WEST SUSSEX COUNTY COUNCIL CONSULTATION

TO:	Arun District Council FAO: Anita Gadner
FROM:	WSCC - Highways Authority
DATE:	12 August 2021
LOCATION:	2 The Poplars, Ferring, BN12 5QL
SUBJECT:	FG/129/21/PL Demolition of existing semi detached dwelling and erection of new detached dwelling. This site is in CIL Zone 4 and is CIL Liable as new dwelling.
DATE OF SITE VISIT:	N/A
RECOMMENDATION:	Advice
S106 CONTRIBUTION TOTAL:	N/A

DRAWING TITLE
Block Plan Proposed

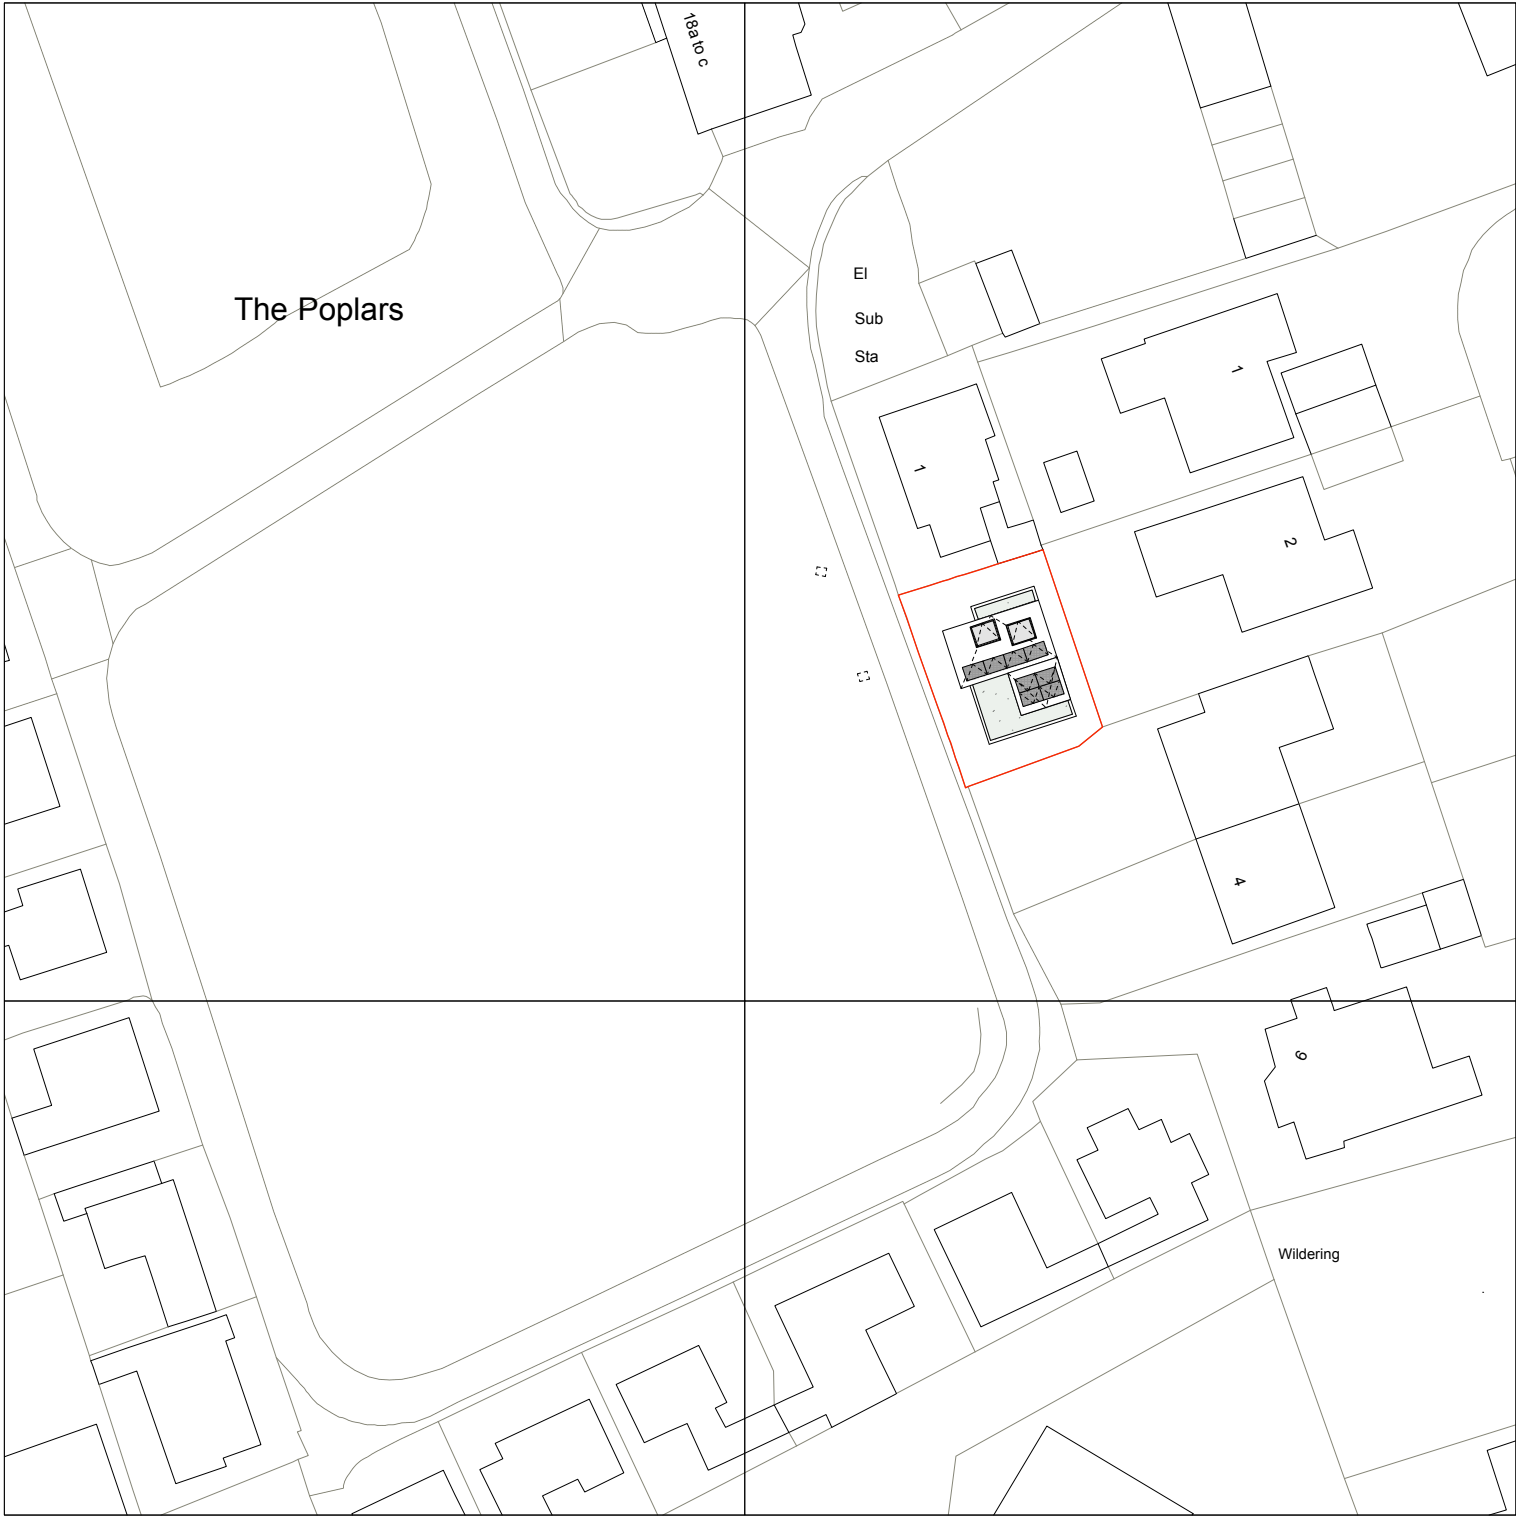
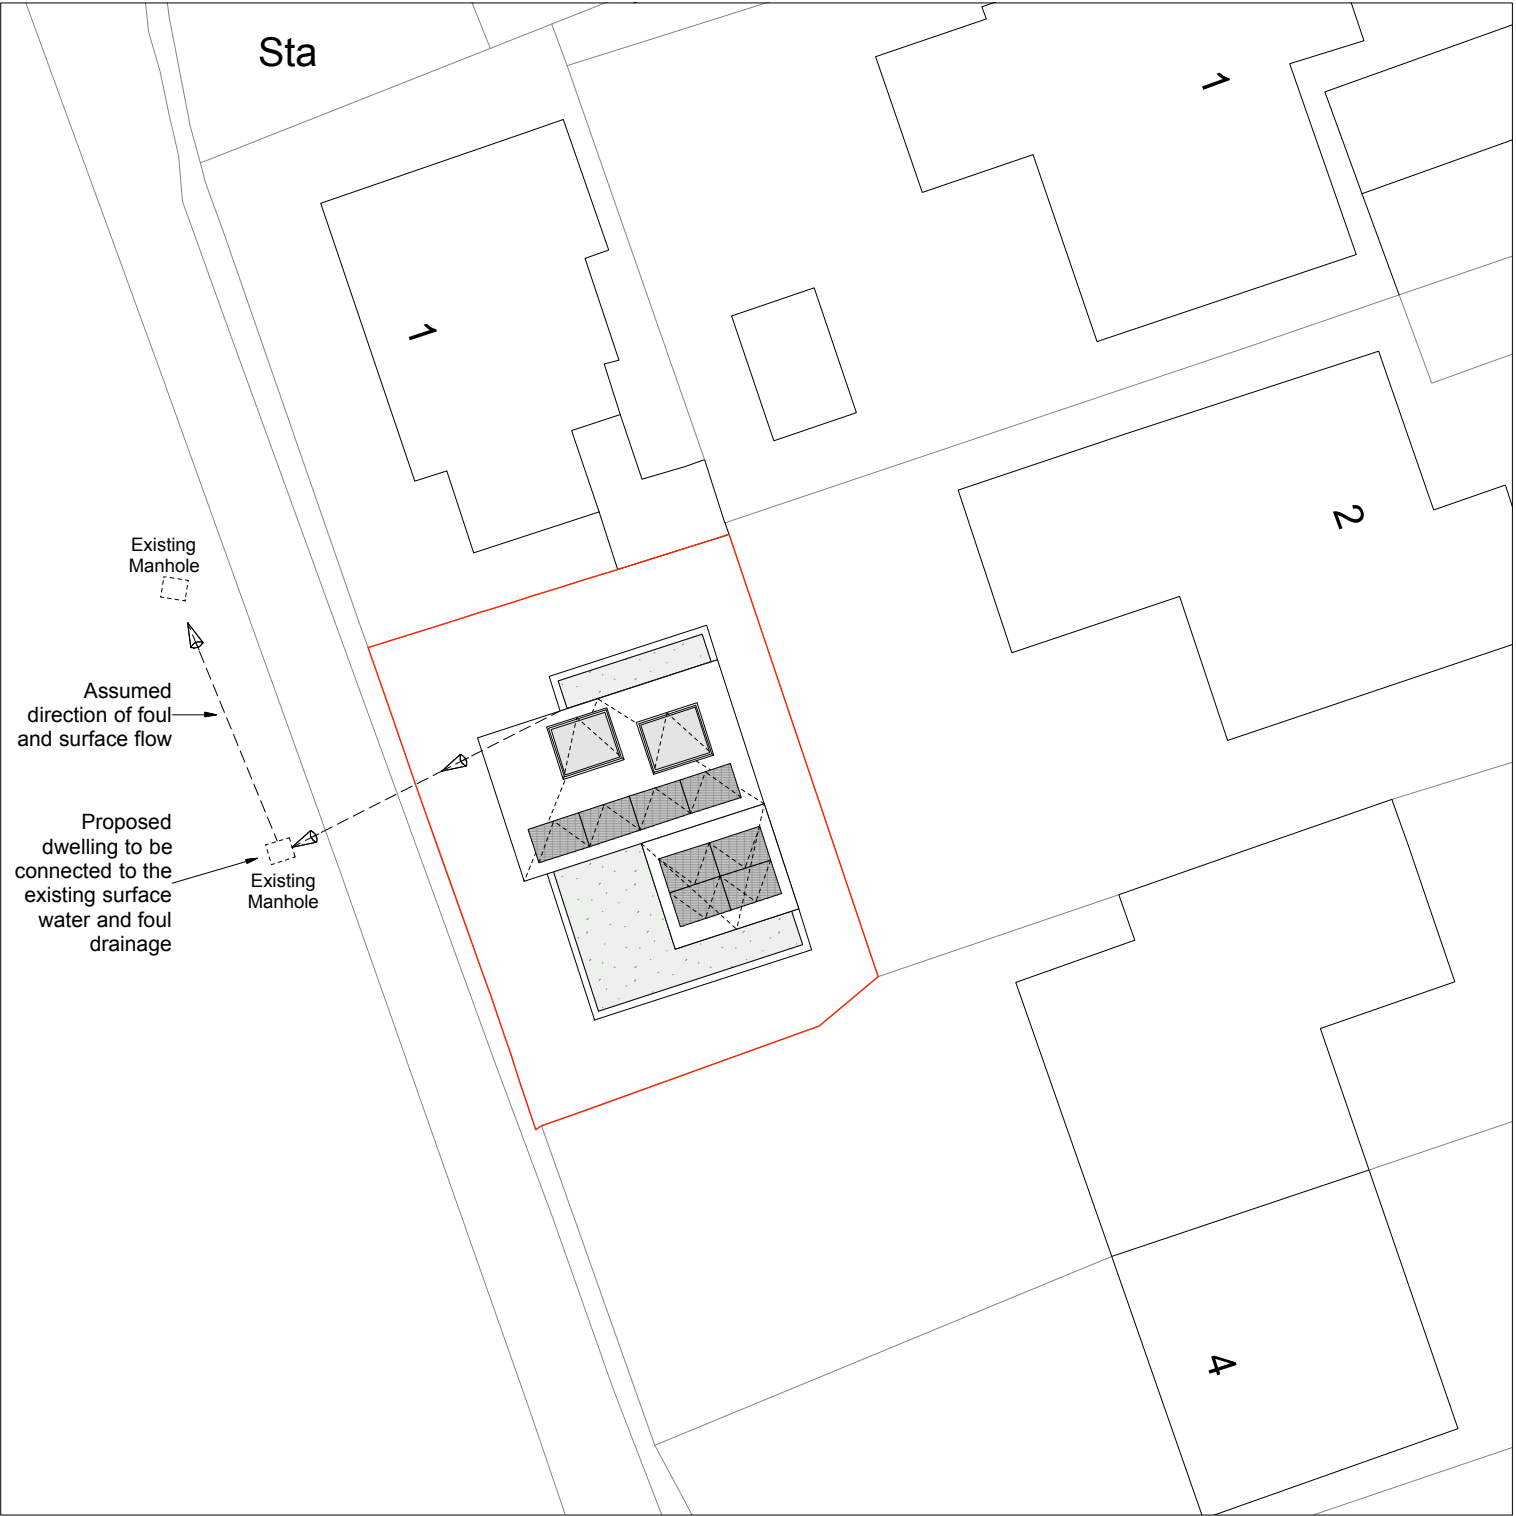
The applicant proposes one car parking space to serve the dwelling. Under Arun Parking Standards, the LHA would anticipate a dwelling of this size in this location to provide at least two car parking spaces. Therefore, overspill parking would have to be accommodated on-street.

Whilst the LHA does not anticipate that the shortfall of one car parking space would result in a highway safety concern, the LPA may wish to consider the potential impacts on on-street parking from an amenity point of view.

should be provided for all new homes. The applicant is advised that for dwellings with an off-street parking provision, 100% of parking spaces should be provided with active EV parking spaces in accordance with the Arun Parking Standards.

On-site turning does not appear achievable, so cars may have to exit the site onto The Poplars in a reverse gear. However, this is not anticipated to result in a highway safety concern.

Regarding cycles, the applicant has demonstrated cycle parking provision for two cycles, in accordance with Arun Parking Standards. The inclusion of cycle parking provision helps promote the use of sustainable transport methods.
